Recommendation Report for Planning Permission for Works or Extension to a Dwelling

REF NO: BE/45/22/HH

LOCATION: 93 Addison Way
Bersted
PO22 9HZ

PROPOSAL: Single storey rear extension.

Proposed Ground Floor Plan

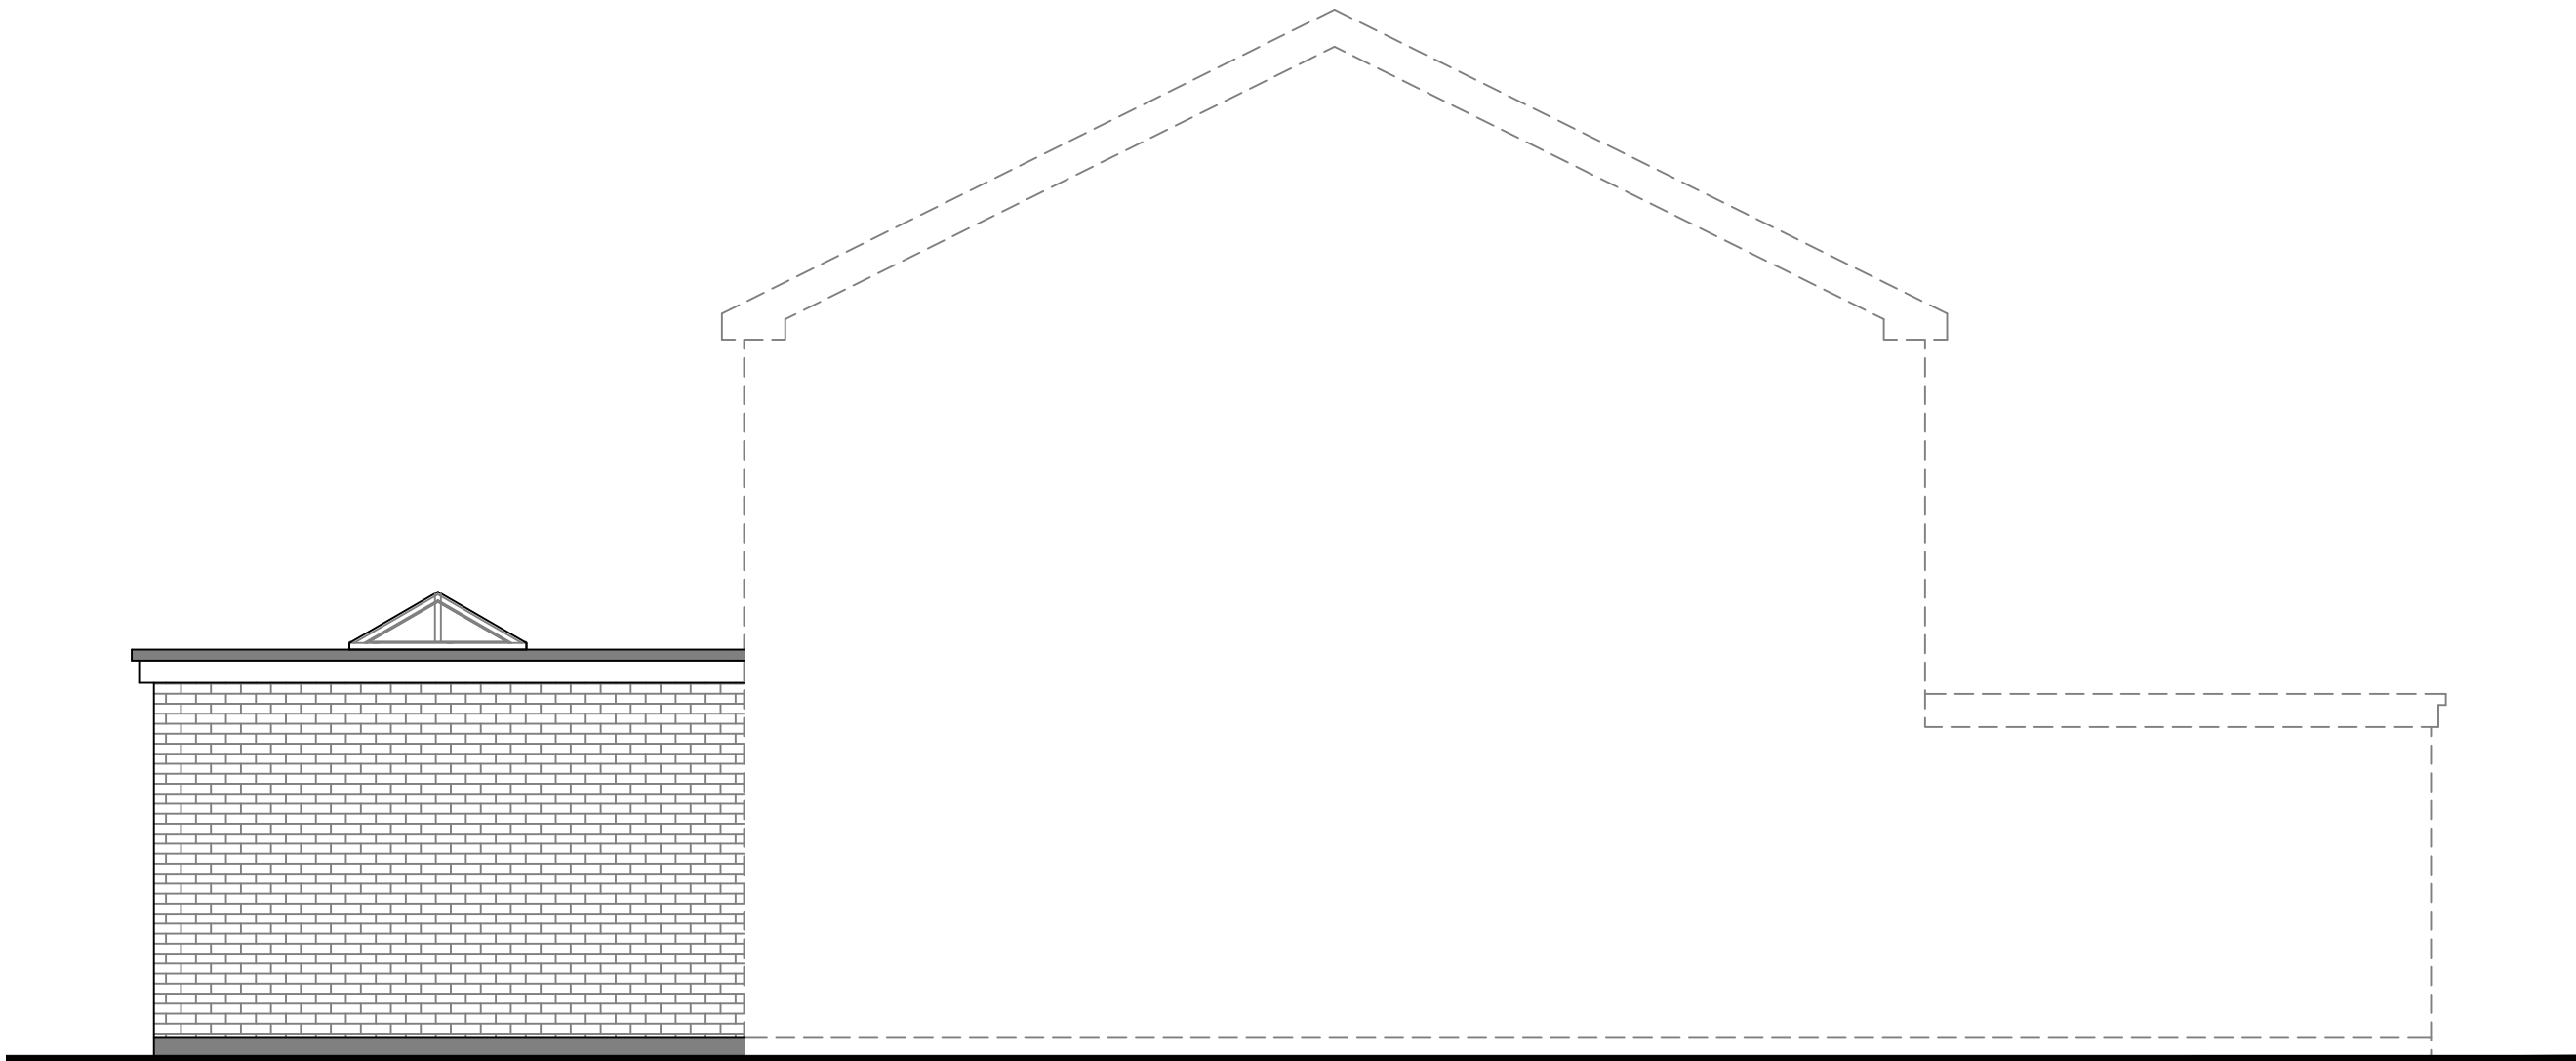
The extension is a modest size, and will project 4m from the rear elevation, with a width of 5.55m. It will have a flat roof, similar to that of the store to the front of the property, and will not appear unduly out of place in relation to the main dwelling. It is in keeping with the character of the property and will not have an adverse impact on its visual appearance. Being to the rear, the proposal will not be visible from the street scene and will have no impact on the composition and appearance of the street. It is in keeping with the character of the area and will have minimal impact on visual amenity.

The extension is single storey and will have a flat roof at a height of approximately 2.75m. This roof will incorporate a roof lantern which will protrude slightly above at around 2.98m but will have no impact on residential amenity. The proposal will retain 0.15m to the north boundary, 22.565m to the east, and 1.1m to the south. These distances are in accord with D DM4 of the Arun Local Plan and are acceptable. Although close to the boundary with No.92, the extension will only project marginally further than the neighbouring rear extension and will have minimal impact on their residential amenity. It does not conflict the 45- or 60-degree rules and will not result in adverse overbearing or overshadowing.

The extension will feature a set of folding doors to the east (rear) elevation. These doors will face into the garden and will not overlook any neighbouring properties. They pose no risk to residential privacy or amenity and are acceptable.
